CITY OF ALBUQUERQUE

June 5, 2012

RE: Lot 13, Sauvignon Subdivision – Grading & Drainage Plan for Building Permit
11524 Zinfandel N.E. P.E. Stamp: 6/7/12 (E22-D007F7.1)

ENGINEER'S SEAL	LOT 13 THE SAUVIGNON SUBDIVISION	DRAWN BY WCUJ
		GRADING AND DRAINAGE PLAN	DATE 5-24-12
			21219-LAYOUT-5-24-12
			SHEET #
			JOB # 21219

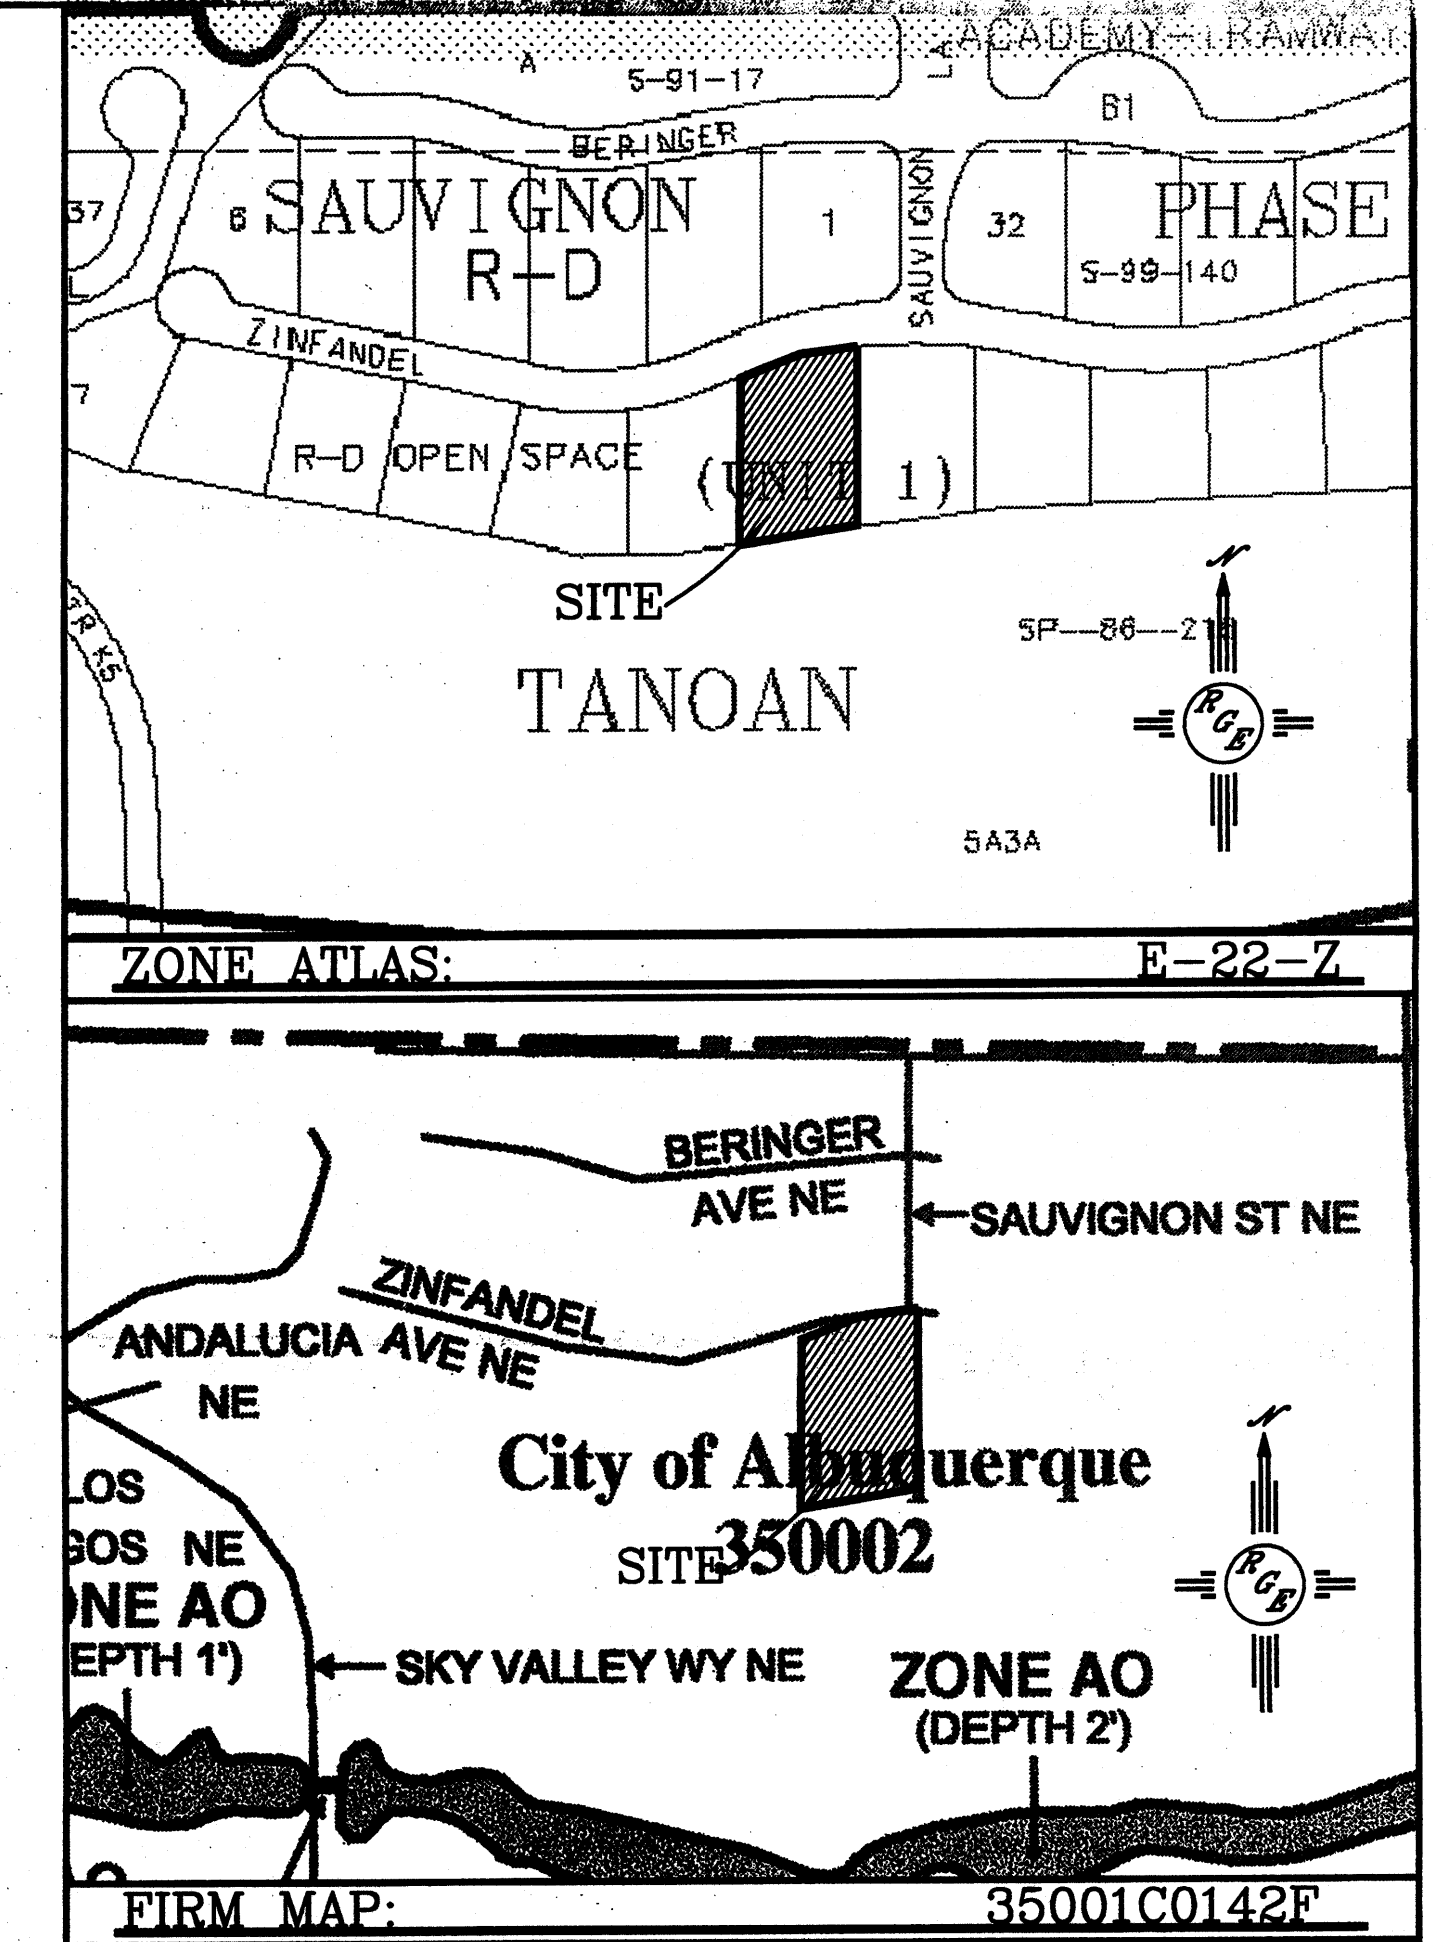
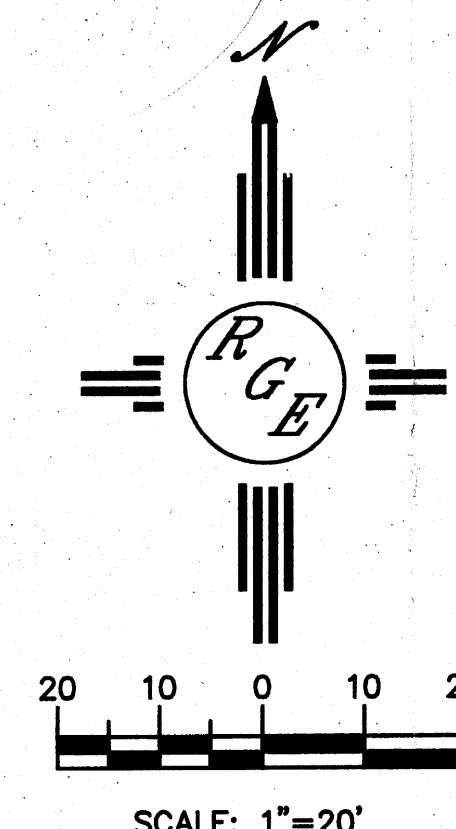
1. Since sidewalk will be required along Zinfandel, grades within the R/W must slope toward the street. Not the 5871 contour is missing near the driveway.

2. Clarify the grades and existing wall type along the east property line. Show that the proposed grades will not be too low (or high) for the existing structure.

3. The 5875 contour near center east side appears to be the 5870 contour, but mislabeled.
4. What is the heavy dashed line along the east and south property line?

5. The cobble swale sketched along the west property line appears to channelize flows from the front yard and driveway through a narrow path against the west "Screen Wall", which also appears to retain nearly 2' of fill at the narrowest point.

- o Check grades for wall design (max. 18" retainage).
 - o Provide a detail/section for the swale to keep flows away from the screen wall.
6. Grading at the NW corner of the lot is different from that shown on Lot 12, recently approved through your office. It also proposes 1'-2' cut at the location of an existing electric transformer (not shown).

7. The drainage shown directed toward the back side of the retaining wall, near the middle of the east side of the lot. Is the wall adequately designed for this condition?
